Permit # **90890**

Proposed Project Description:
10x14 Deck attached to house

BUILDING PERMIT REPORT

DATE: 11/Aug/99 ADDRESS: 59 Buca Run CBL: 336-E-069
 REASON FOR PERMIT: To Construct 10' x 14' deck
 BUILDING OWNER: Patrick Lally
 PERMIT APPLICANT: SAC /Contractor
 USE GROUP R-3 CONSTRUCTION TYPE 5-B

PLOT PLAN

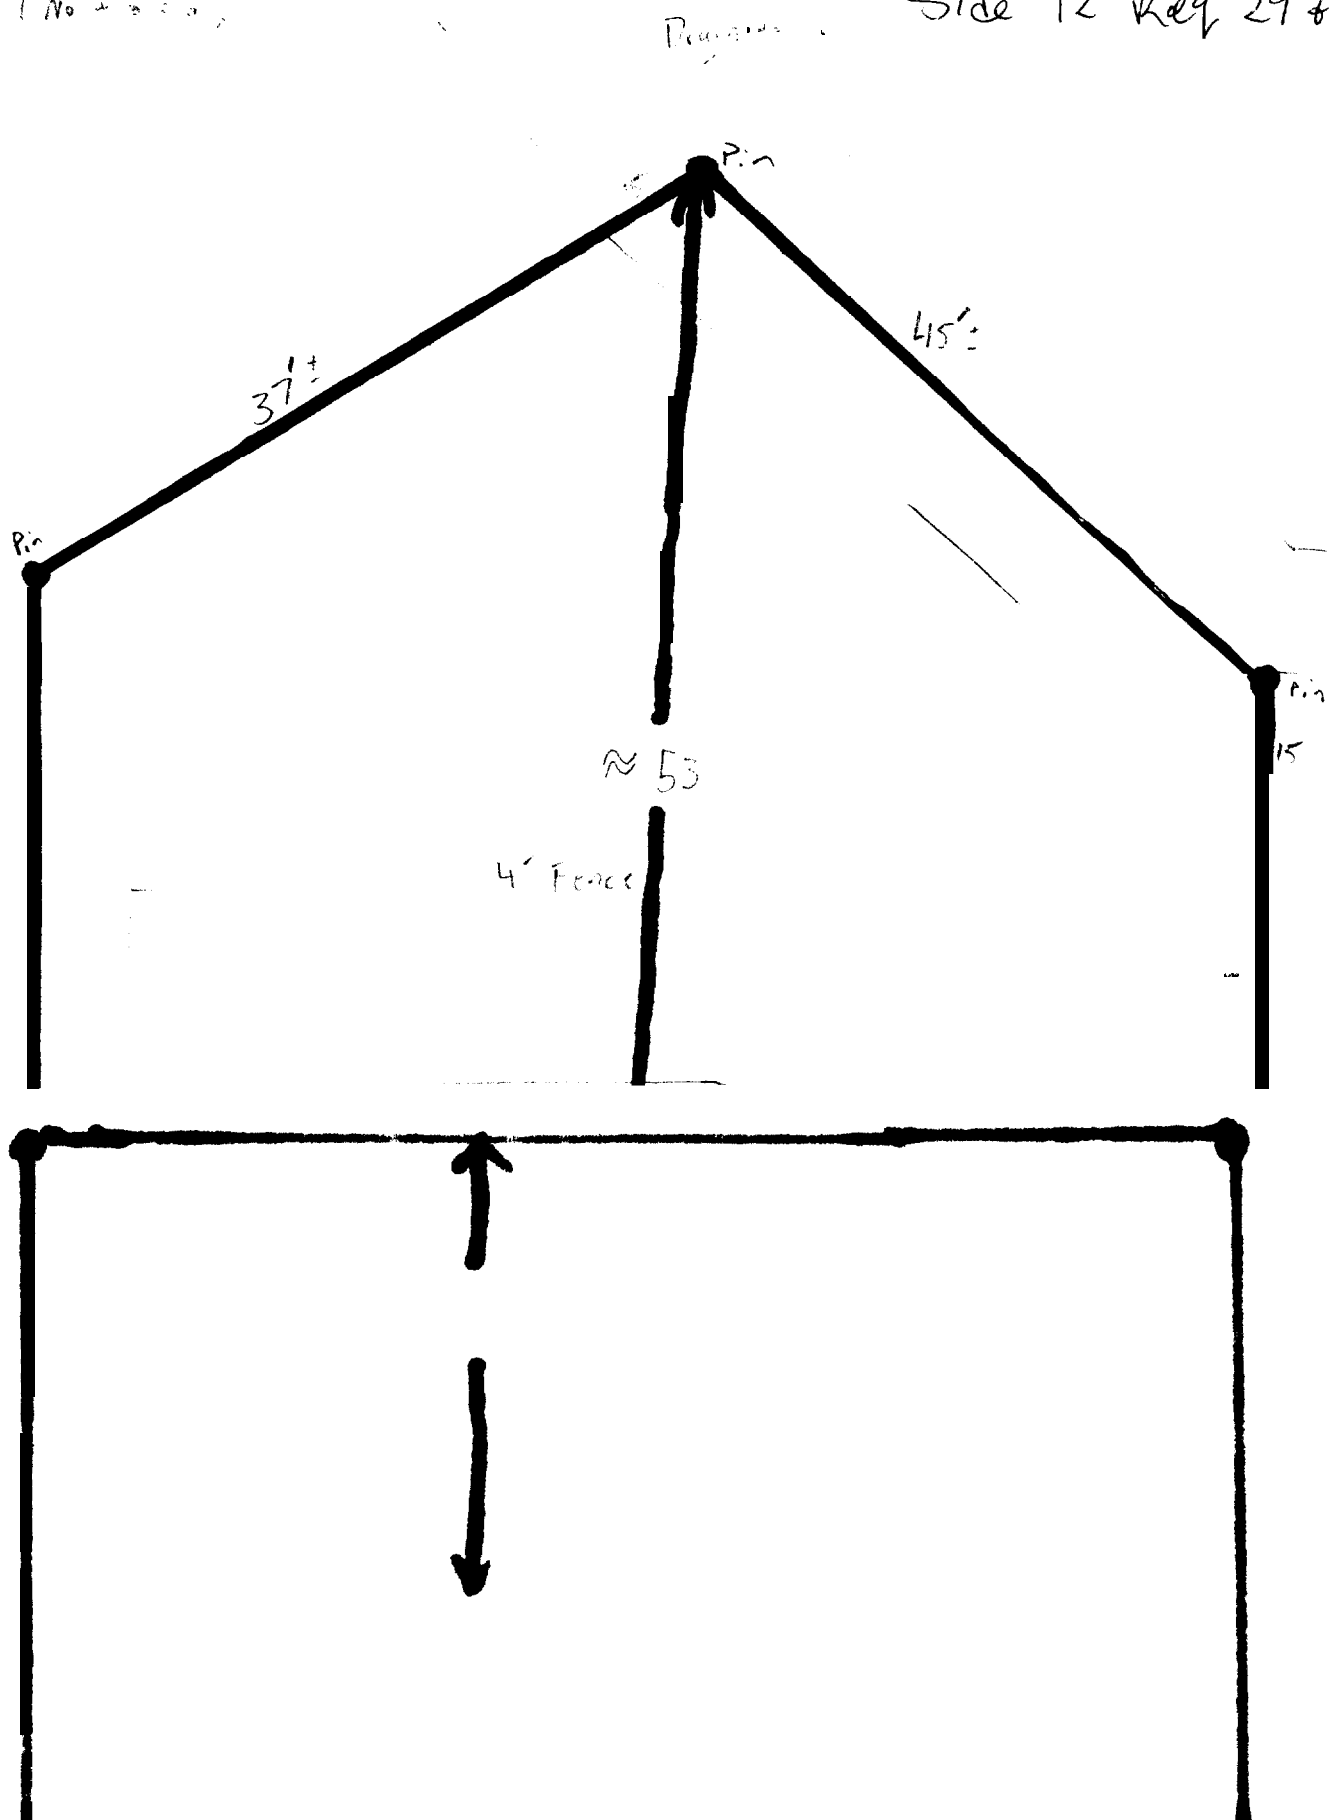
- *35. MAX. SPAN OF 2x6' @ 16" O.C. IS 9'4".
- *36. FOUNDATION PIERS SHALL BE A MINIMUM OF 4' BELOW GRADE. ON FOOTINGS WITH ANCHOR BETWEEN THE TWO. ALSO A FASTENER SHALL BE USED BETWEEN PIER AND FRAMING.

- 37.
- *38. PIER: MAX SPAN OF 8'.
